12364 - North Penrith Stage 3B Development Application

RESPONSE TO AGENCY SUBMISSIONS

**NORTH PENRITH
 STAGE 3B
 DRAINAGE LAYOUT**

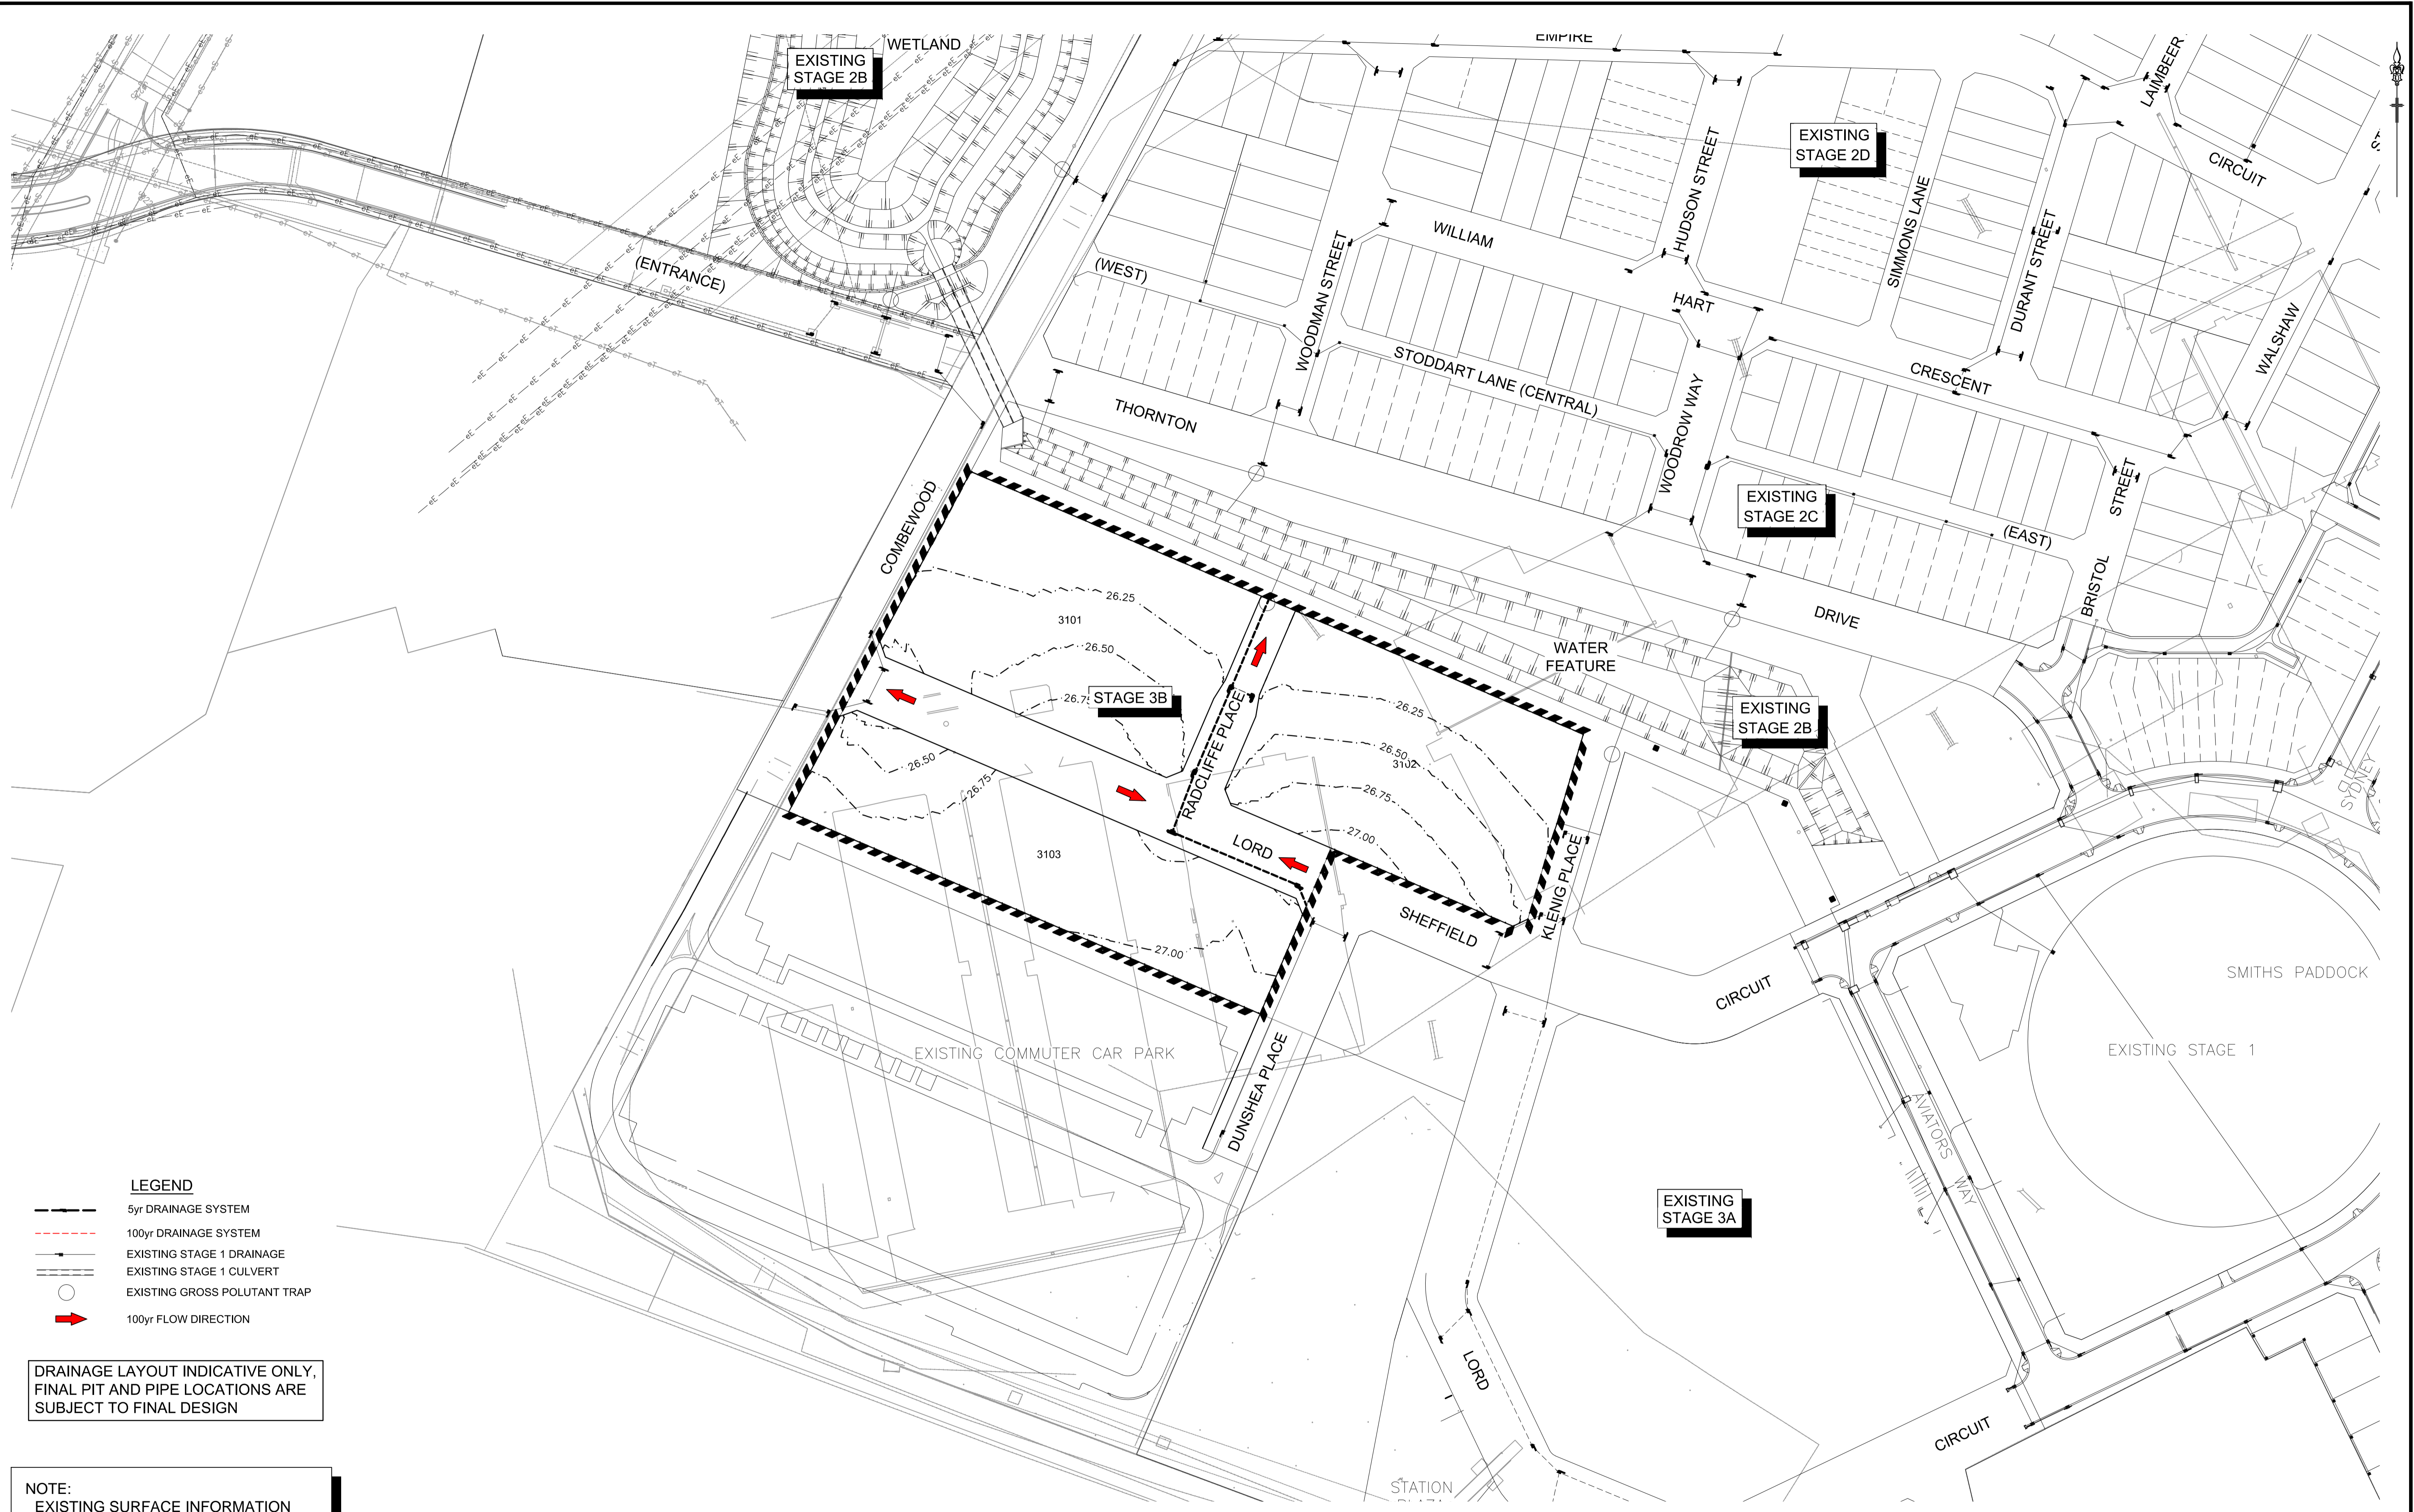
Water Cycle Management	
<ul style="list-style-type: none">No details provided regarding the proposed GPTs. Council recommend they are not visible and that access for maintenance is appropriate for Council's maintenance fleet. Design considerations should include but not limited to the following:<ul style="list-style-type: none">All GPTs should be sized to ensure that they can treat the 3 month to 1 year ARI flow.As the GPTs are to be designed for the pre-treatment of a wetland, it is important that they be designed to remove coarse sediment loads.All GPTs should be designed to ensure there is no risk of increased flooding upstream of the GPT.Council should be given an opportunity to review and approve the proposed GPTs so that life cycle costs and maintenance issues can be considered. The proponent should provide Council with a detailed operation and maintenance manual which includes estimated costing.	<ul style="list-style-type: none">Noted. This matter can be dealt with through the Department's standard conditions of consent.

NORTH PENRITH
STAGE 3B
ROAD TYPICALS
& LONGSECTIONS

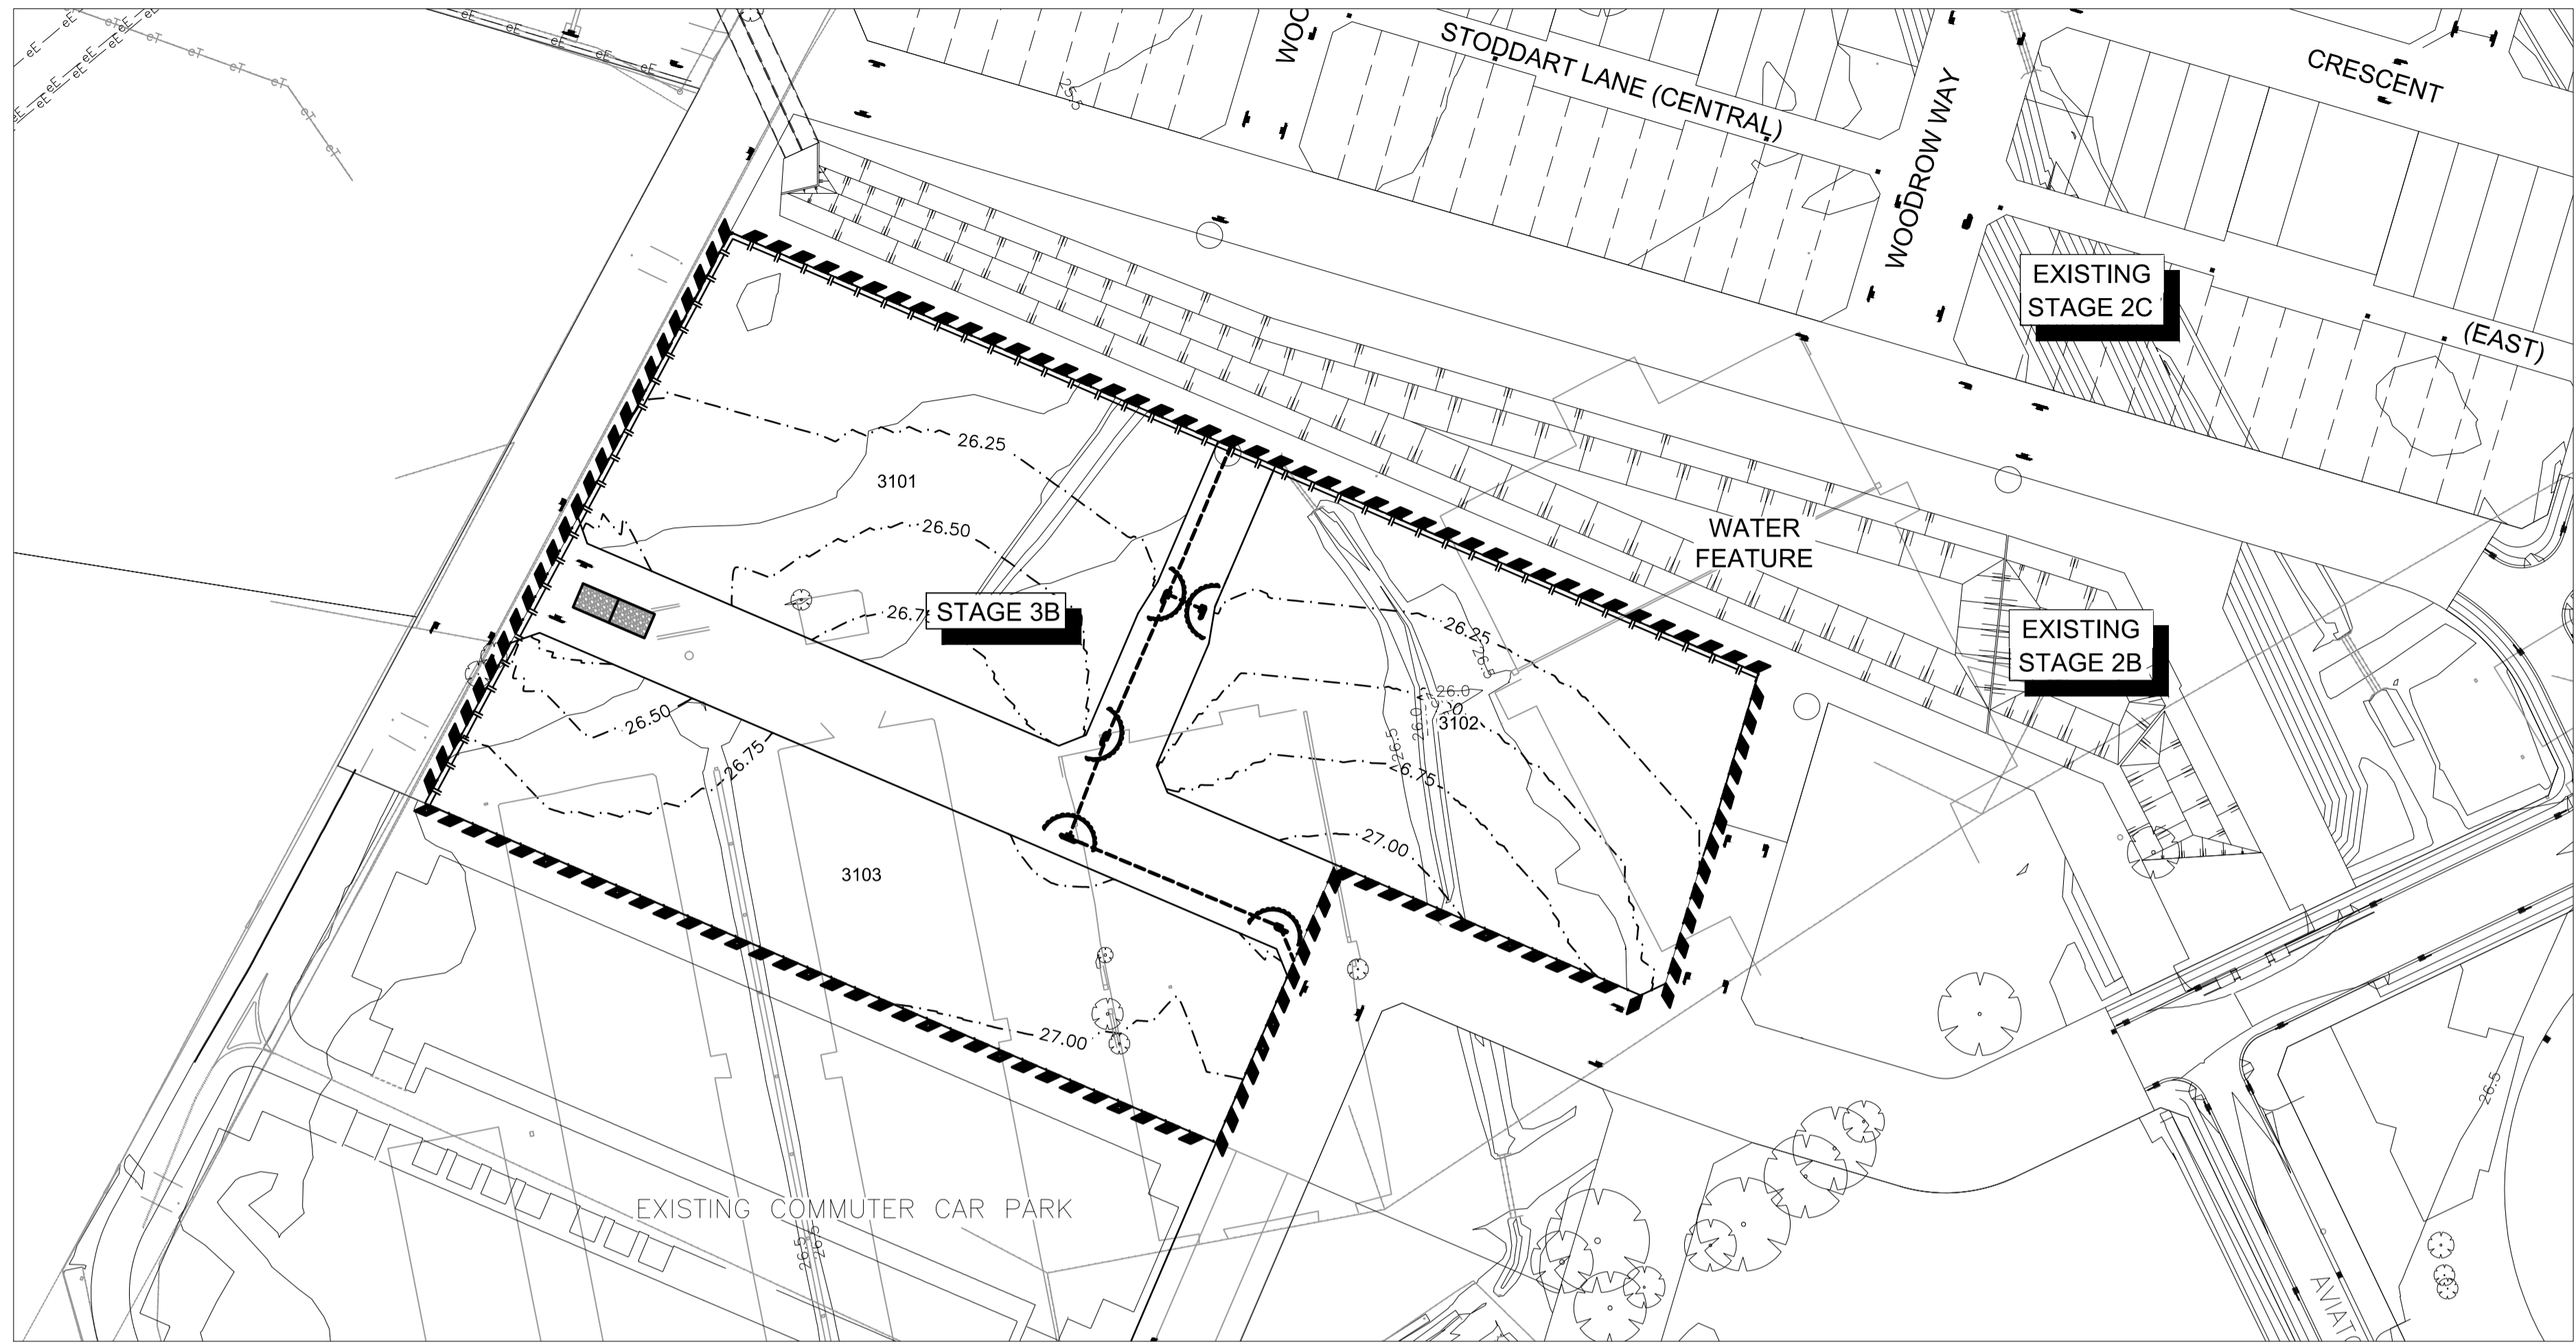
<ul style="list-style-type: none"> Street cross sections are inconsistent with Council standards. Council's standard is 1.5m, however this path in a 3.6m verge means there is insufficient space for street trees. Also, there are both 3.8m and 3.9m verge widths. 	<ul style="list-style-type: none"> The proposed street cross sections are consistent with those approved under the Concept Plan Approval. There are only minor adjustments where new street cross sections need to integrate with existing conditions (such as on Thornton Drive and on Combewood Avenue at the interface with the commuter car park). 1.5m footpaths are provided in all locations, and street trees are still provided within the 3.6 verge.
<ul style="list-style-type: none"> Fencing details should be provided. Council requires assurance that opportunities for graffiti are minimised and surrounding and streetscape amenity is not compromised by the height and scale of fencing. Of particular 	<ul style="list-style-type: none"> The boundary to the commuter car park is already fenced; this fencing was installed as part of the car park construction. UrbanGrowth NSW does not intend to install additional fencing.
